November 20, 2015

SUBJECT: Permit Modification Request for Section 404 Individual Permit and Section 401 Individual Water Quality Certification for the US-74 Monroe Connector/Bypass in Union and Mecklenburg Counties. STIP R-3329 and STIP R-2559, Division 10, Debit WBS Element 34533.1.TA1 in the amount of \$570.

Reference: US Army Corps of Engineers (USACE) 404 Permit issued May 8, 2015; Action ID: SAW-2009-00876
NC Division of Water Resources (NCDWR) 401 Water Quality Certification Permit issued March 6, 2015; NCDWR Project No. 02-0672 V3

PERMIT DRAWINGS
SHEET 213 OF 267
REVISED: 11/9/2015

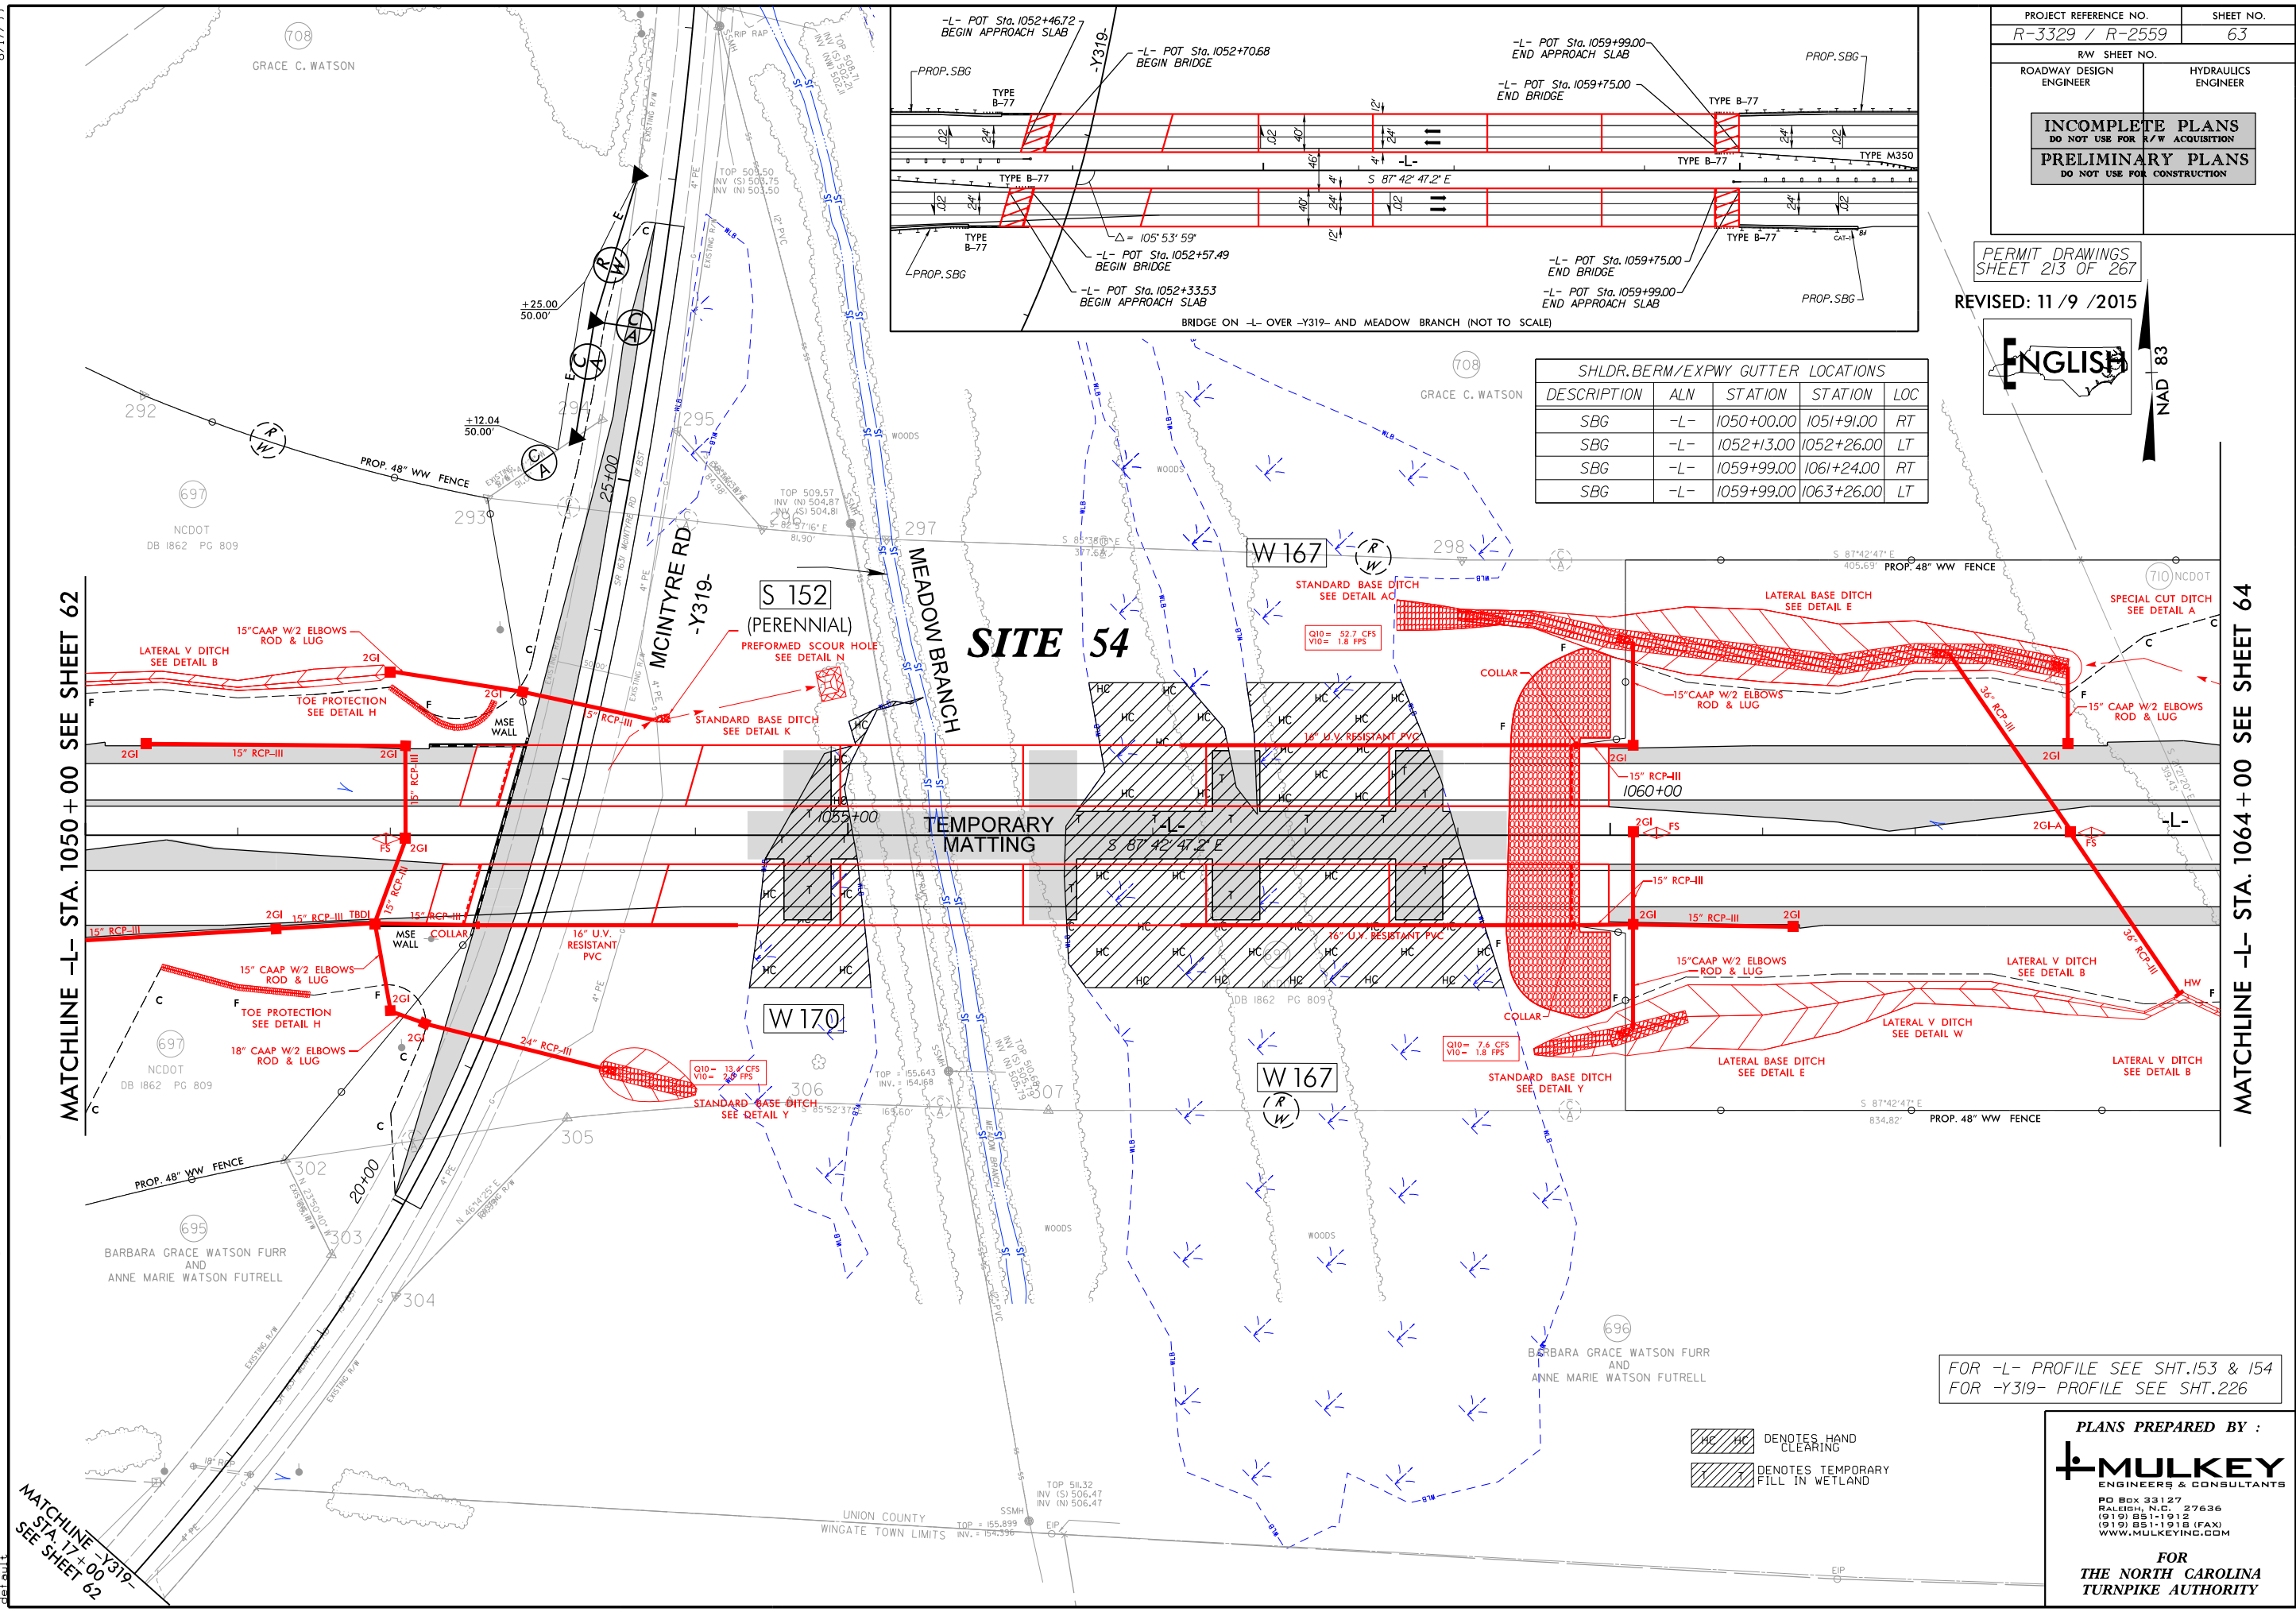
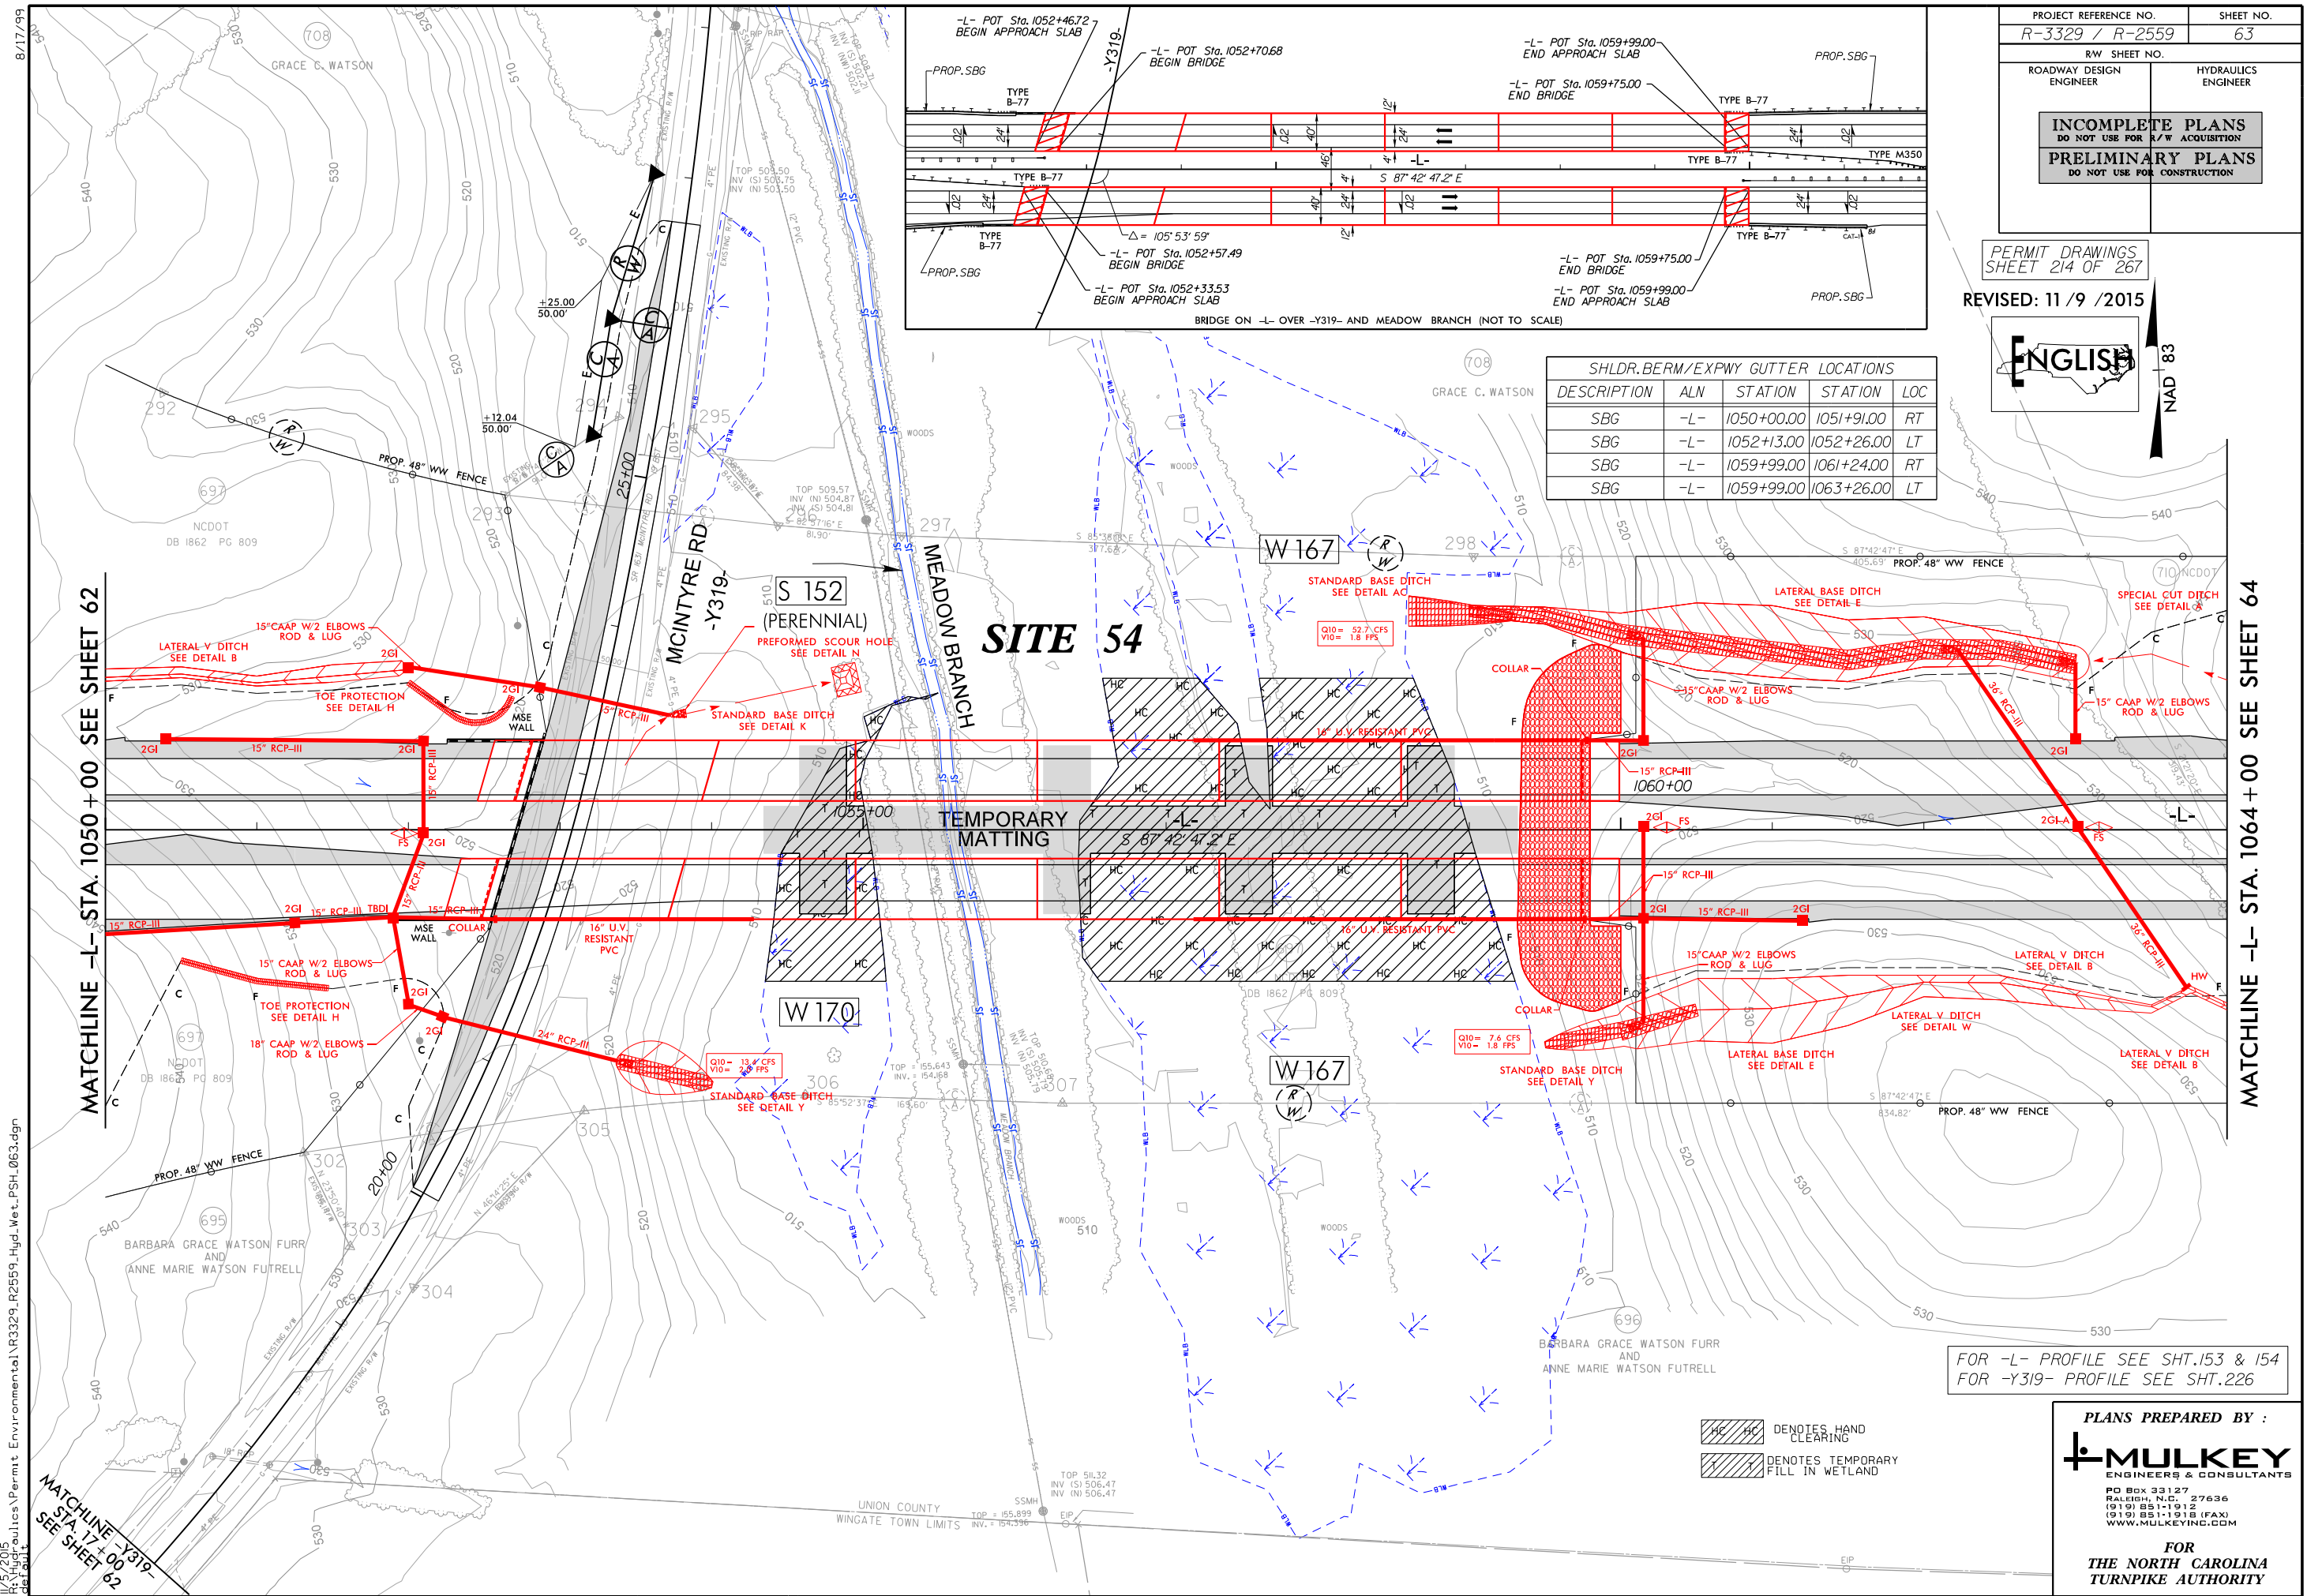
Permit Site 54 (Revised Permit Drawings 213 and 214 of 267):

As noted in our correspondence on October 26, 2015, Site 54 is the crossing of Meadow Branch and the associated high quality wetland. As initially permitted, it was anticipated that it would be necessary to have 2 temporary work pads - along either side of the bridge - with work fingers extending towards the middle. However, taking the bridge design, access, and sensitive environmental conditions into consideration, the bridges can be constructed from a single work pad between the two bridges with the work fingers extending outwards.

This minimization will reduce the temporary impacts by 0.15 acre, from 0.52 to 0.37 acre.

The areas previously impacted by the work pads, will now only be impacted by hand clearing. This increases the hand clearing at Site 54 by 0.15 acre.
